Dear Messrs Jackson and Stone,

Thank you for allowing me to contribute to the examination. In Part One of this document I have given a synopsis of the A449 issues that I am concerned about. In the second part of this document I have analysed the applicant's submission and the examination to date with discussion and questions. Part Two is grouped into three themes: the A449, potential kettle holes and the applicant's plan disclaimers.

2. The DCO Shortcomings – Analysis & Questions:

Plot Date: 06 December 2019 12:53:19
File Name: \\UK\h2p\psw001\1\1\1\ENVIRONMENT\Practice Areas\GIS\Projects\M54\M6 Link\Workspace\Stage 3 Figures\Landscape and Environment - Noise and Vibration\HE514465-ACM\EGN\M54_SW_PR_Z\DRN-0003 - Figure 11.2 - Noise Affected Routes.mxd

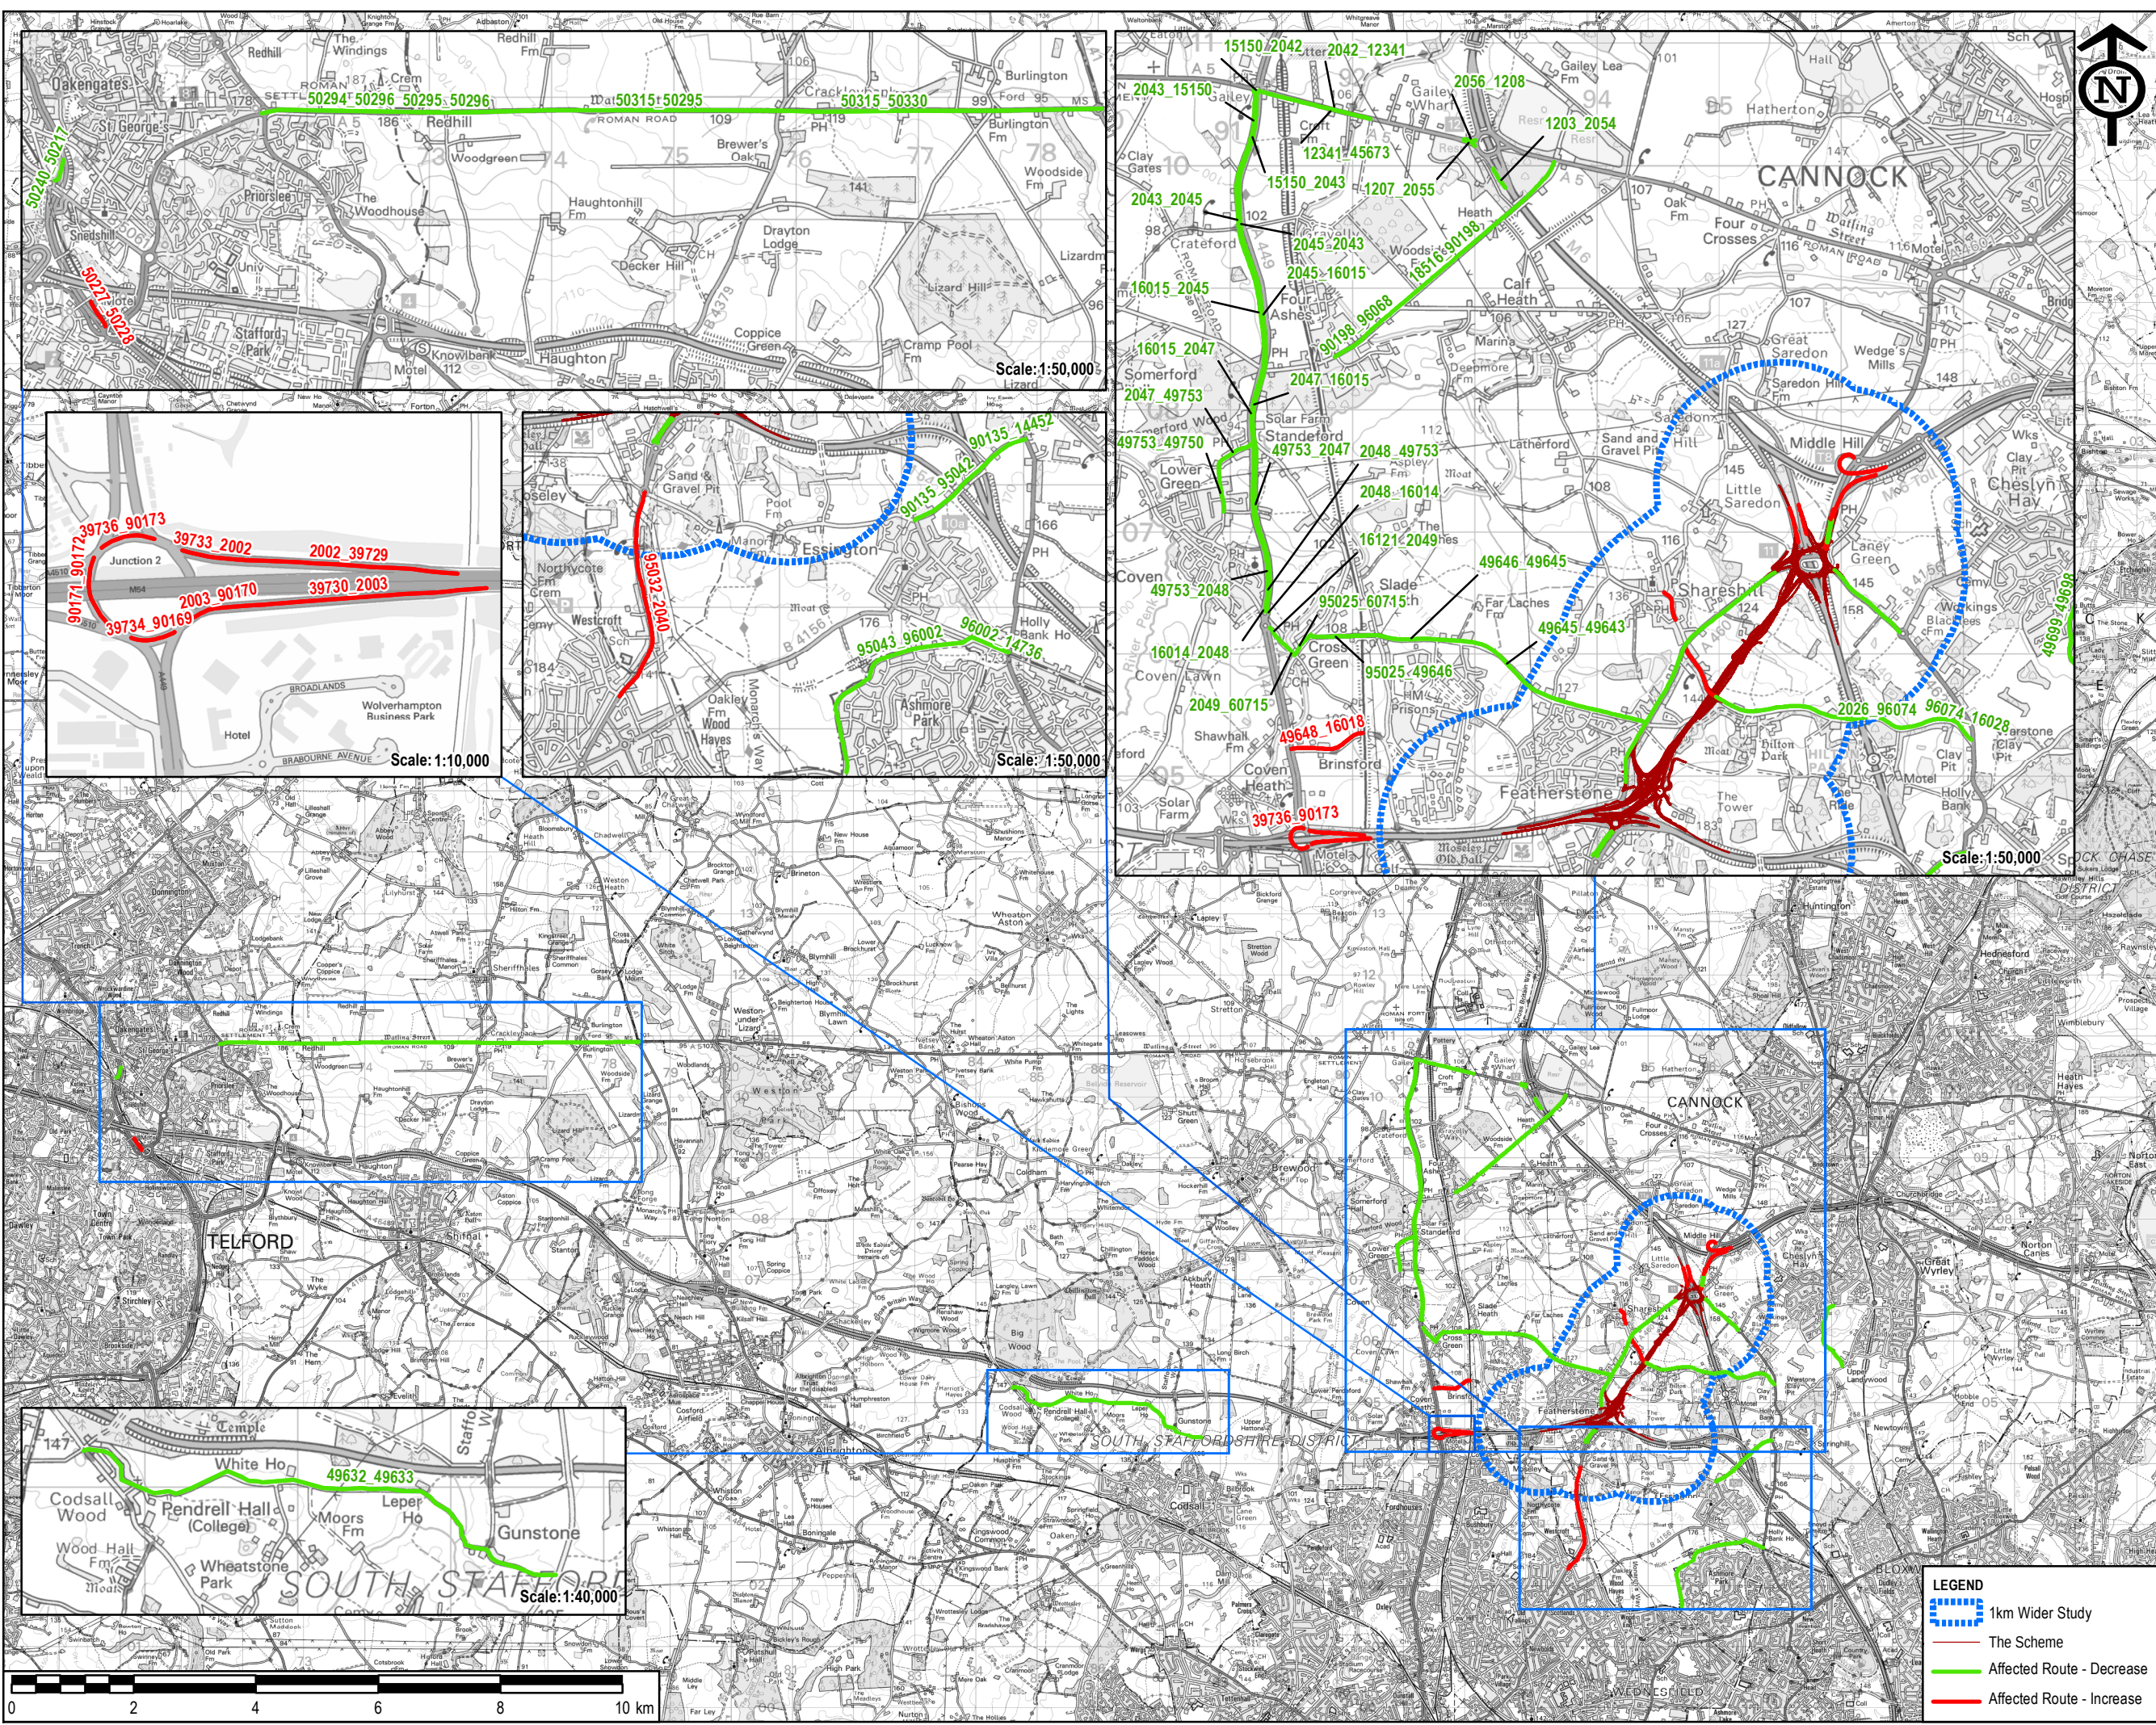
Question 3: Why is the 1.8km section of A449 immediately to the north of J2-M54 missing from the applicant's Appendix 11.5⁷ data/analysis? The applicant's *Figure 11.2 – Noise affected routes*⁸ visually demonstrates this particular omission.
